26 October 2021

**FURTHER INFORMATION REQUESTED
STATE SIGNIFICANT DEVELOPMENT APPLICATION
RESPONSE TO ENVIRONMENTAL IMPACT STATEMENT
Newstan Mine Extension Project – SSD-10333**

Rita Nakhle
Senior Town Planning Officer
Sydney Trains

Predicted subsidence contours

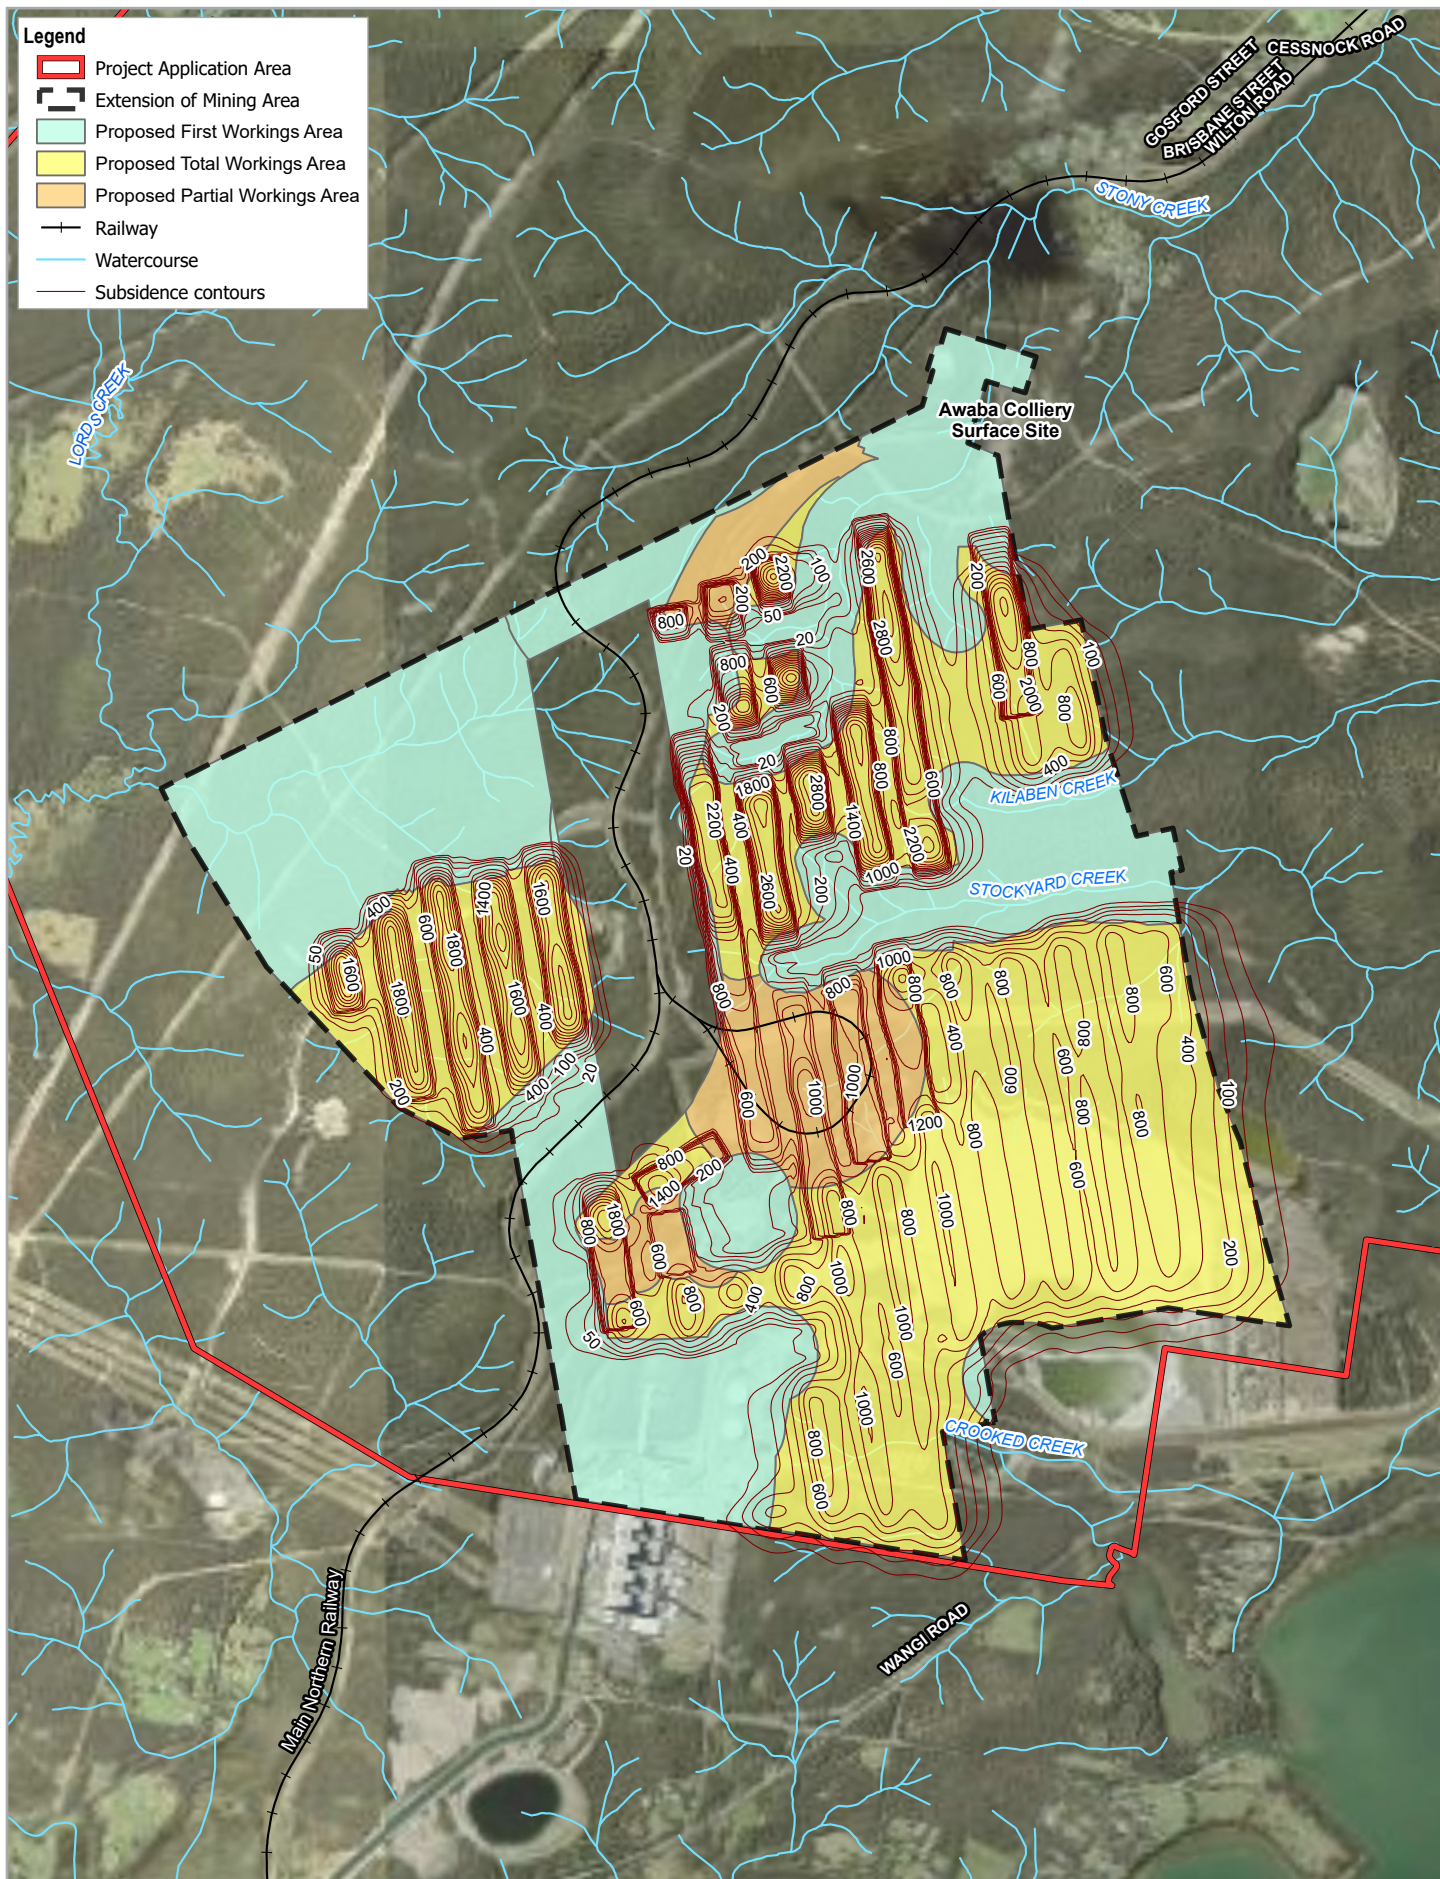
Sydney Trains raises concerns over the potential significant safety and operational impacts associated with the indicated subsidence levels both under and within proximity to the live (passenger and freight) rail corridor, non-operational corridor and rail assets. This includes concerns relating to instantaneous subsidence potential.

Detailed Subsidence Impact Assessment including engineering assessment and extraction plans, for the Rail Corridor (operational live passenger line, non-operational line and assets) must be provided.	Applicant to consult with Sydney Trains in regards to details required in the Impact Assessment.
